KIRKLEES METROPOLITAN COUNCIL INVESTMENT & REGENERATION SERVICE

Reference No:	2024/62/93476/E
Site Address:	7, Hall Drive, Norristhorpe, Liversedge, WF15 7AH
Description:	Erection of single storey front extension and external alterations following removal of existing dormer extension.
Recommending Officer:	Nicole Helliwell

Officer Report

PROPOSED ROOF PLAN
Scale 1:50@A1

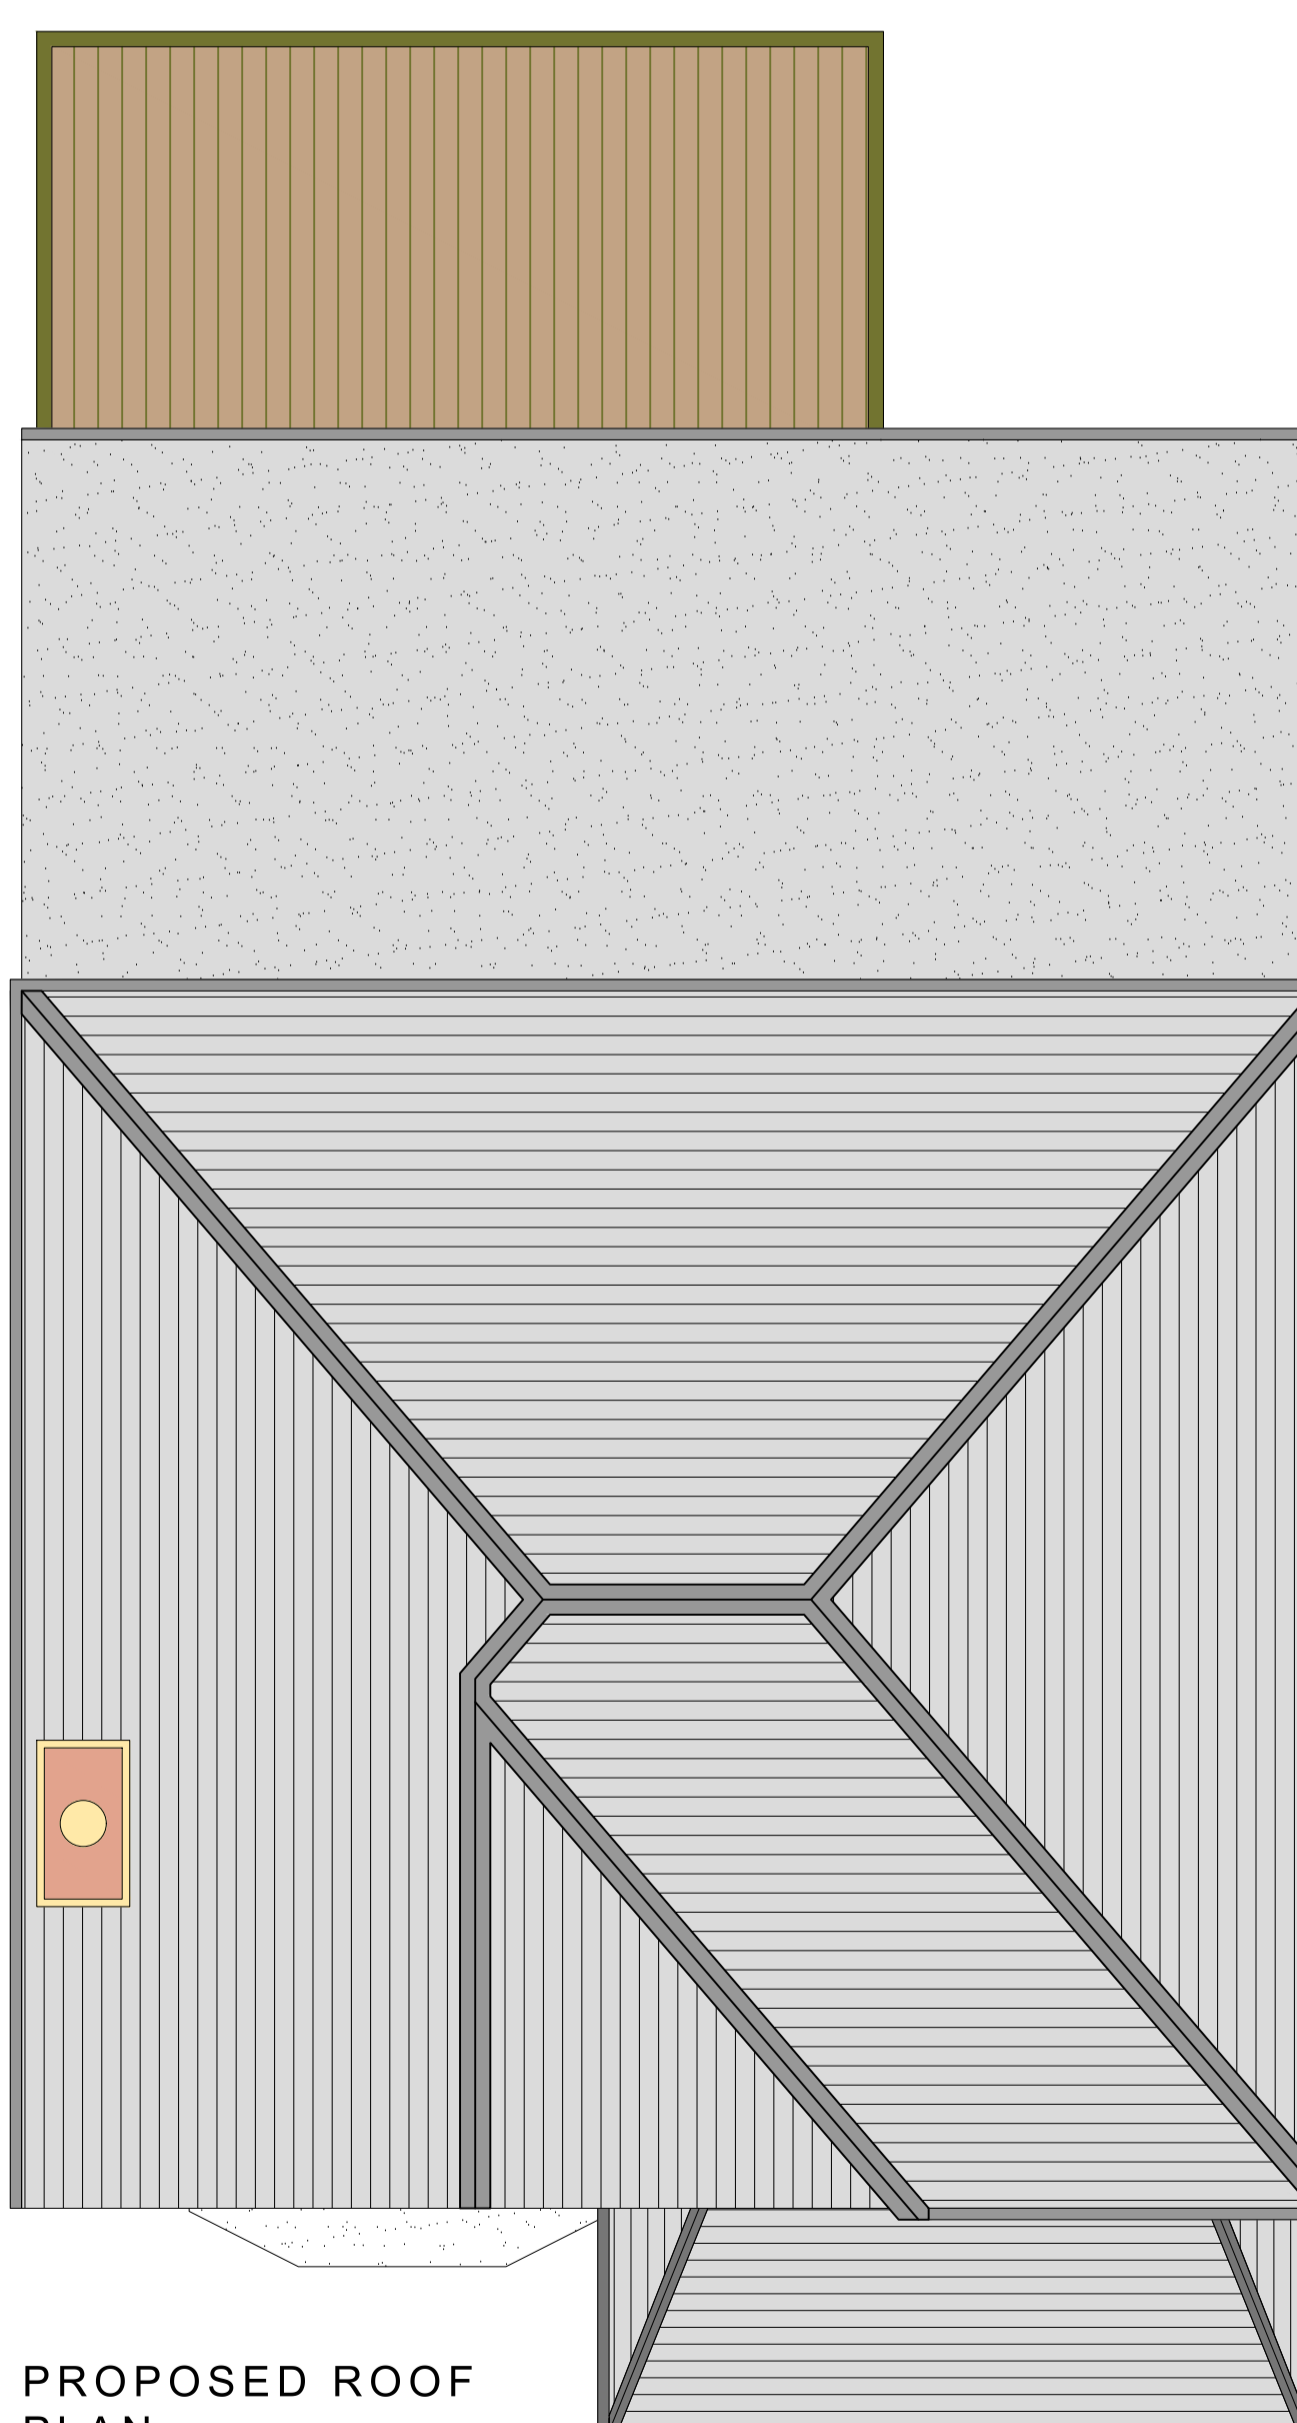
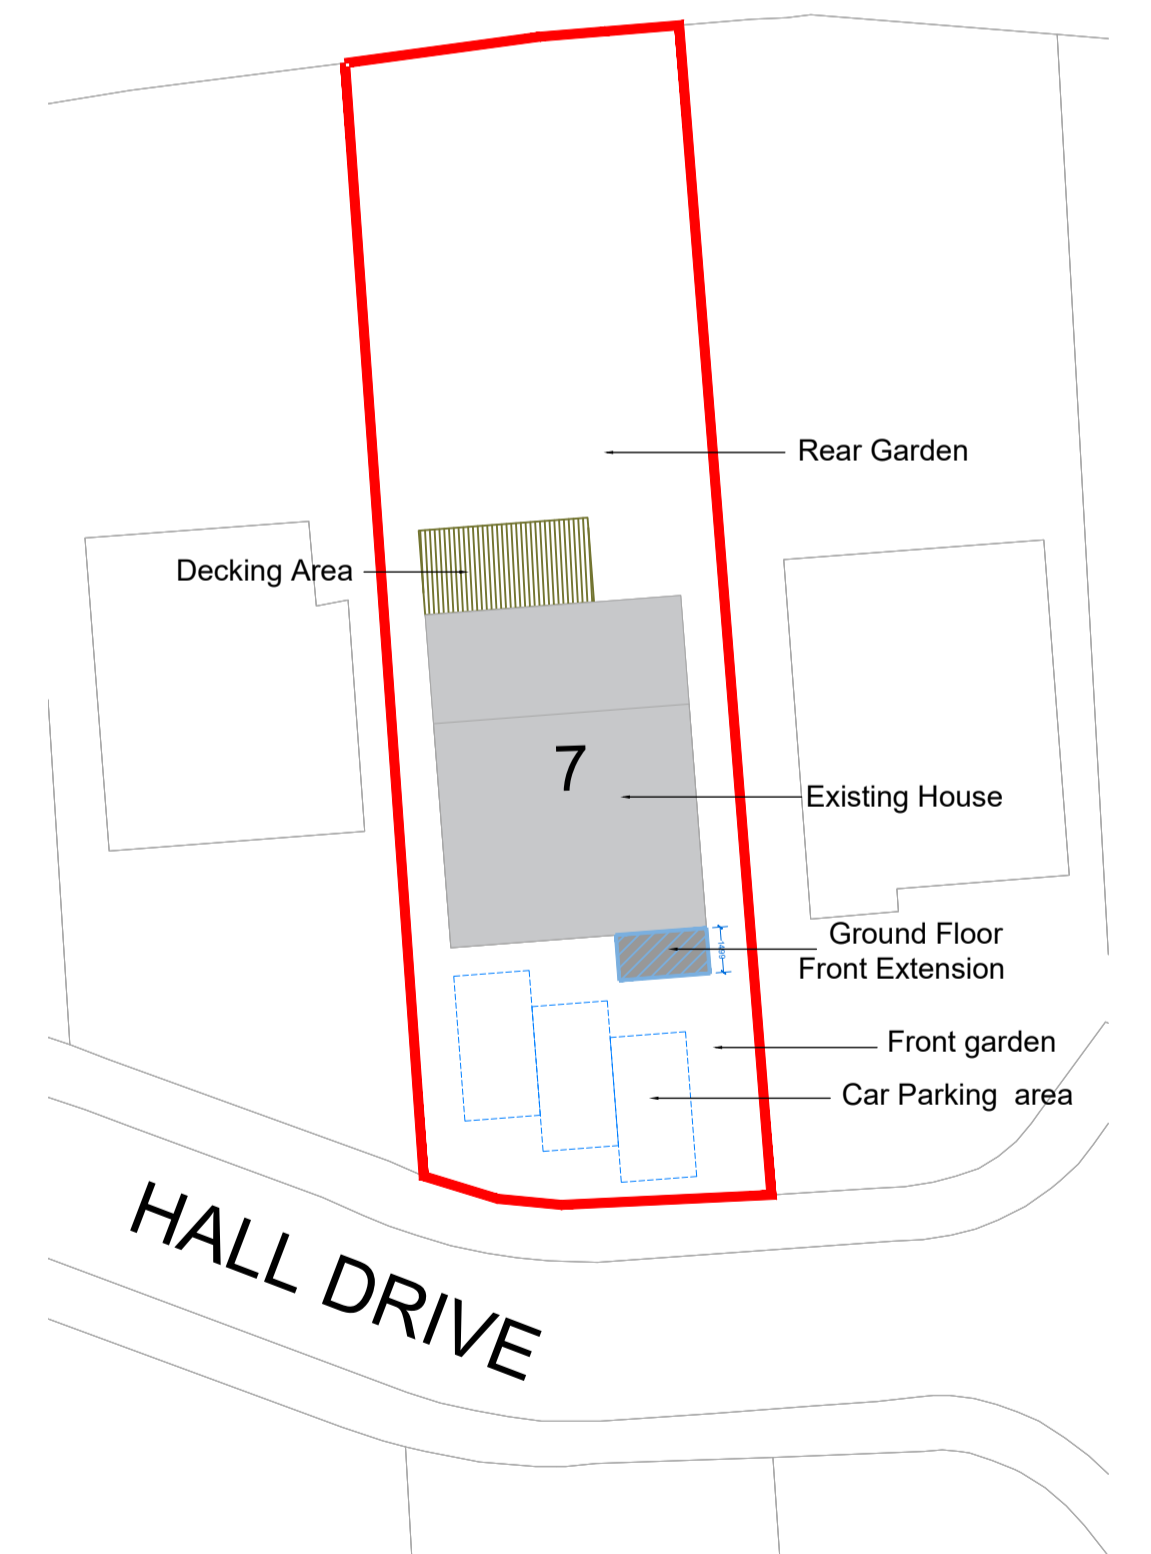
The proposed single storey extension would project approximately 1.5m from the front elevation of the original dwellinghouse. The enlargement would be constructed in a material palette to match the host property and would be appropriately designed. The extension would be modestly proportioned and would appear subservient to the host property. Furthermore, the enlargement would be sited on lower ground and would retain a distance of approximately 7.3m from the pavement such that it would not appear unduly prominent from public vantage points. For these reasons, it is considered that the proposal would not have any significant visual impact on the character and appearance of the host property and wider street scene.

The proposal would create an additional bedroom, which would intensify the domestic use at the dwelling. However, the submitted plans demonstrate that off street parking would be retained for three vehicles which is considered to represent a sufficient provision for a five bedroom dwellinghouse. Therefore, the proposed development is considered acceptable in accordance with Policies LP21 and LP22 of the Kirklees Local Plan, Chapter 9 of the NPPF, Principles 15 and 16 of the Kirklees House Extensions and Alterations SPD and the Highways Design Guide SPD.
